(RR-037) ELAF: South and north connection of proposed permissive WCH route

Deadline 6: Thursday 15 December 2022

re: REP5-018 Deadline 5 Applicant Comments on Submissions Received at Deadline 4 and ELAF's deadline 4 comments REP4-043

Figure 4 – Temporary PRoW Diversions (Cable Route)

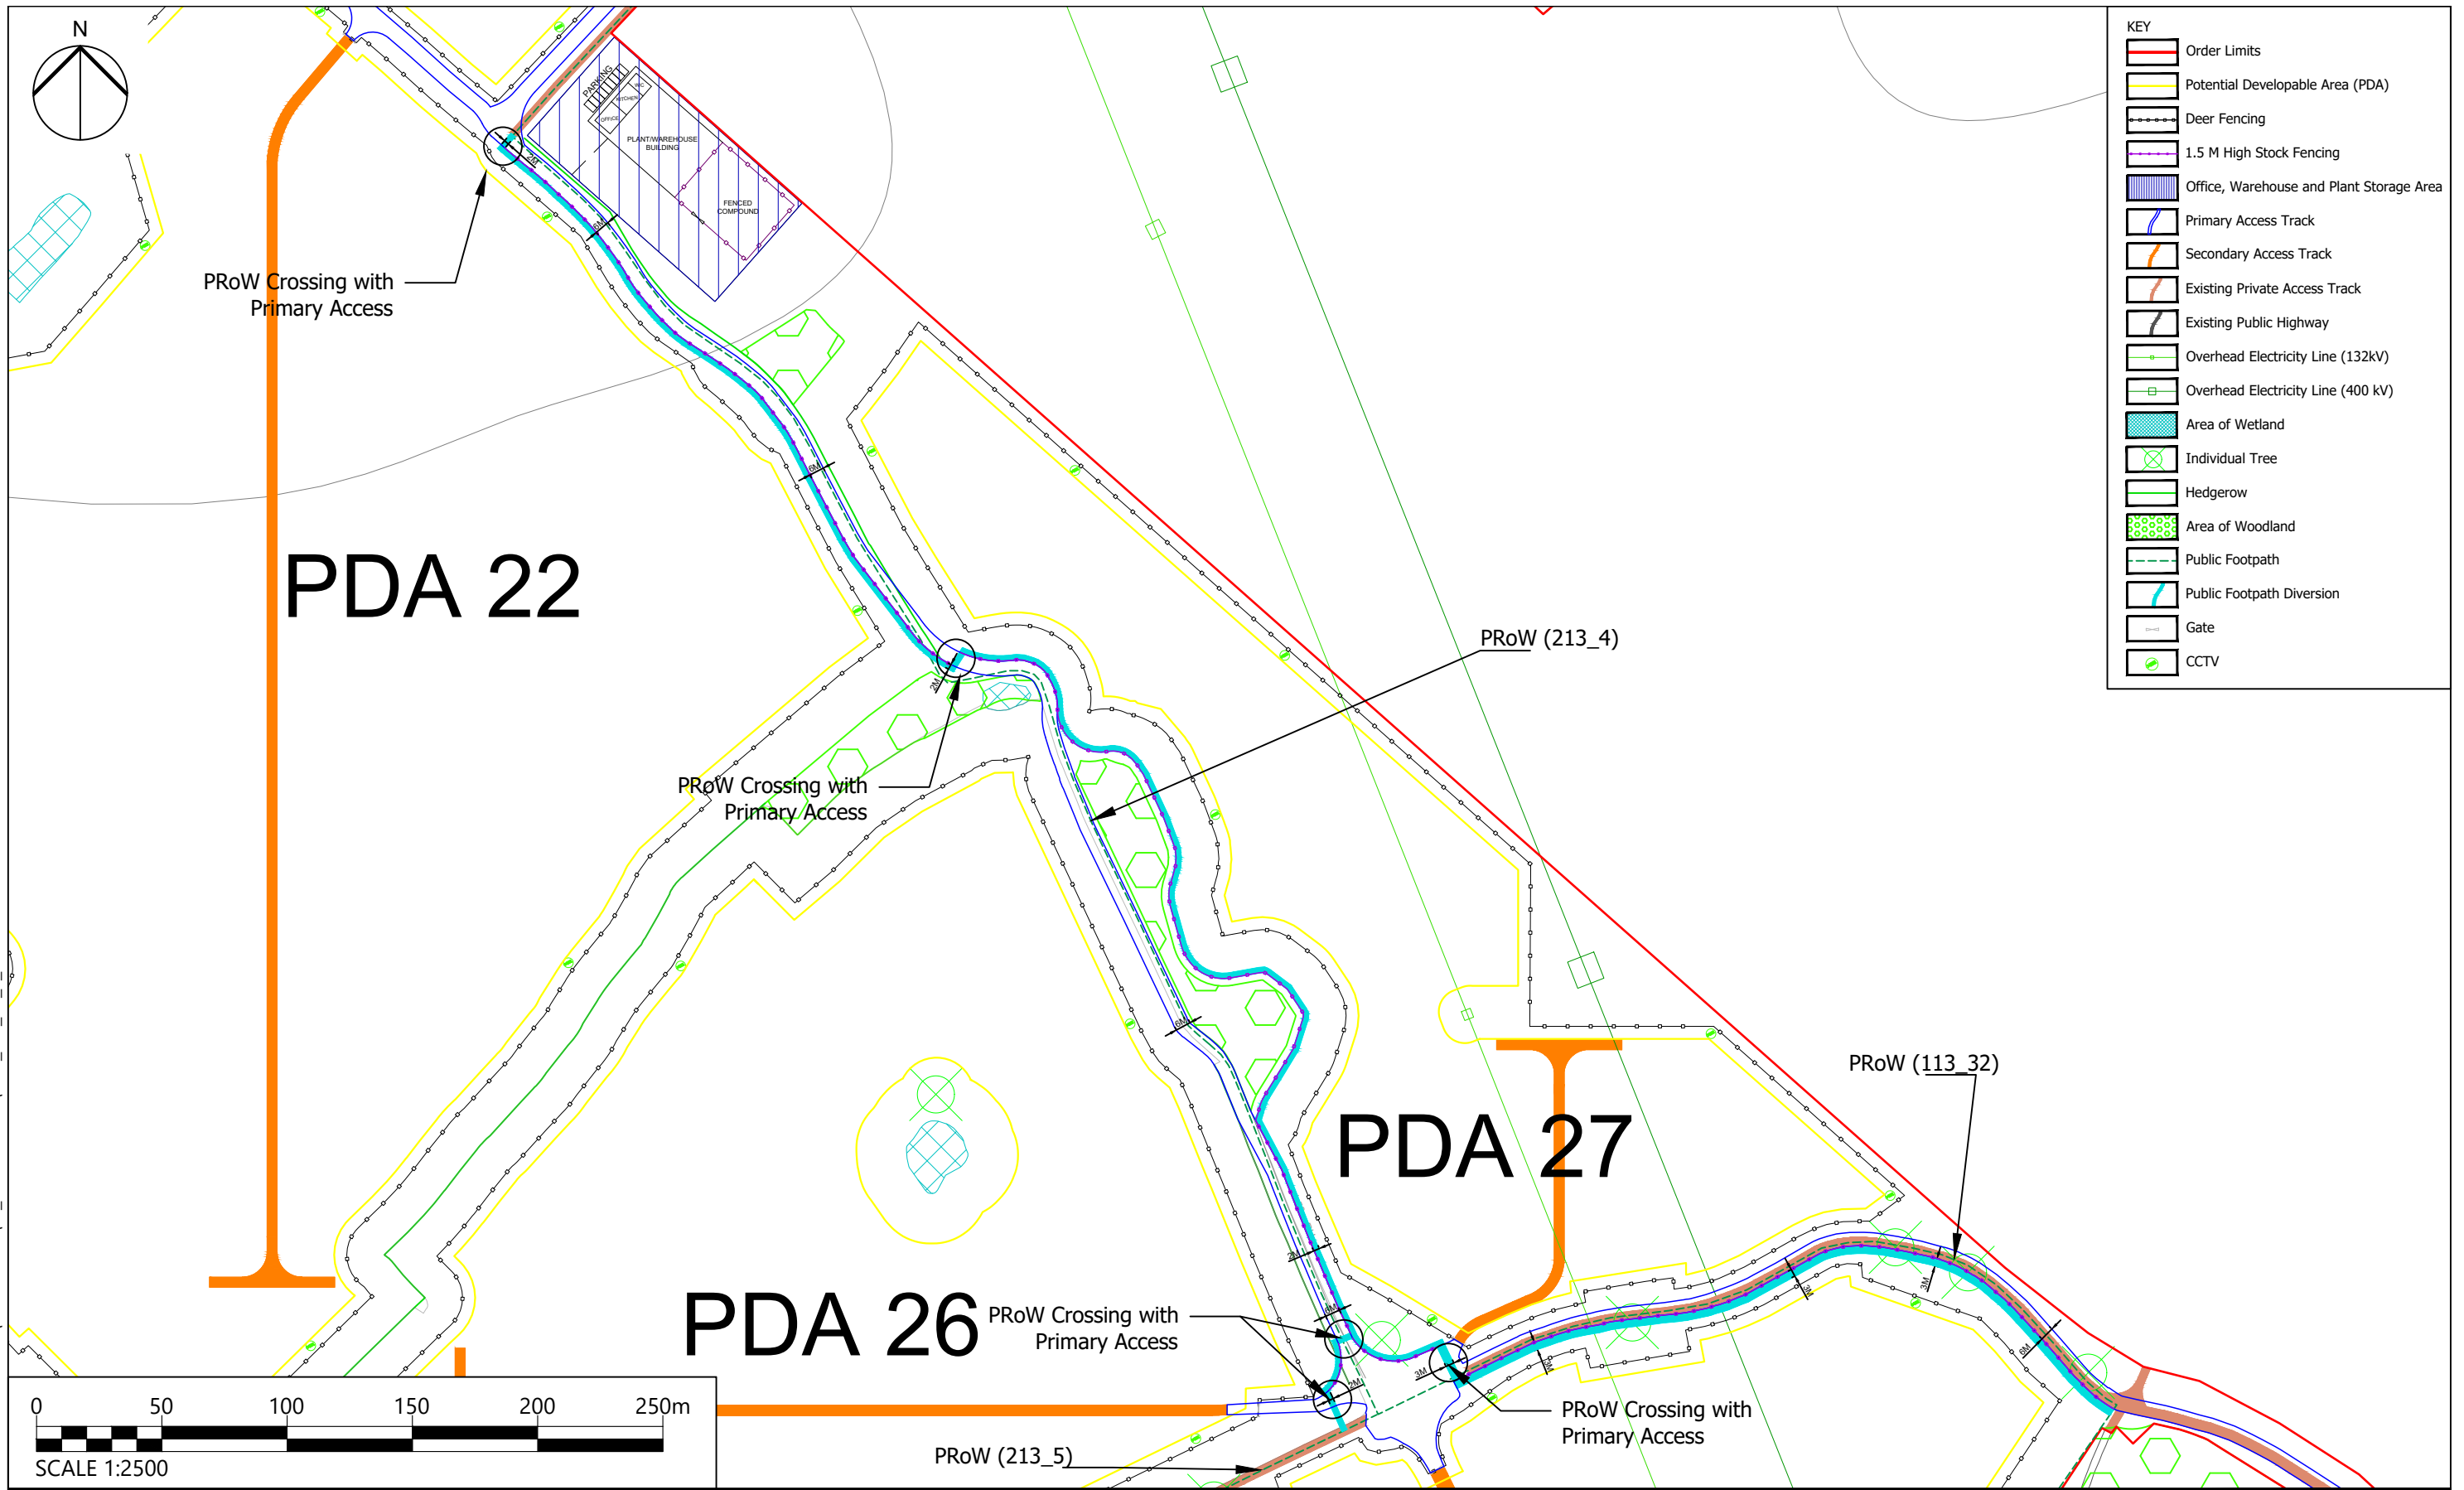
- 3) In ELAF's deadline 4 representation (REP4-043), in keeping with NPPF 100, ELAF requested that a connection could be made at the southern end of the permissive route. One option proposed was along the cable route. The applicant's representation REP5-018 included the following Figure 2 and the associated comment:

The yellow route aligned with PROW 213_19 shows the approximate alignment of the additional path suggested by ELAF. However this is constrained by existing hedgerows and its location within Work Number 4, identified only for works associated with the Grid Connection.

At the accompanied site visit on 6 December, Mrs Katherine Evans, ELAF Chairman and representatives from Longfield Solar were able to consider & discuss ELAF's request on the ground for a connection along the cable route to Waltham Road. The applicant advised that whilst most of the land of the cable route would revert to farmland once the cable laying works had taken place, there would be about a 5 metre width above the cableway itself that could not be ploughed, etc. The cableway land can be accessed through the slightly gappy hedge at the southern end of the north-south permissive route / greenway. The cable route passes through (blue coloured) land parcels 3/4 & 2/1E & 2/6 where rights are to be acquired permanently. A 5metre wide WCH permissive route west to Waltham Road and then south on the east side of Waltham Road, inside the order limits, would provide a safe off-road connection to the PROWs on either side of Waltham Road and to Chantry Lane, a public road which is unfortunately currently severed at its southern end by the A12. The impression gained is that Longfield Solar are now minded to treat ELAF's request for improved WCH connectivity along the cableway favourably.

It would be even better if the permissive route was extended all the way west along the cableway to The Grove with the adjacent Boreham bridleway 48 [PROW 213_48].
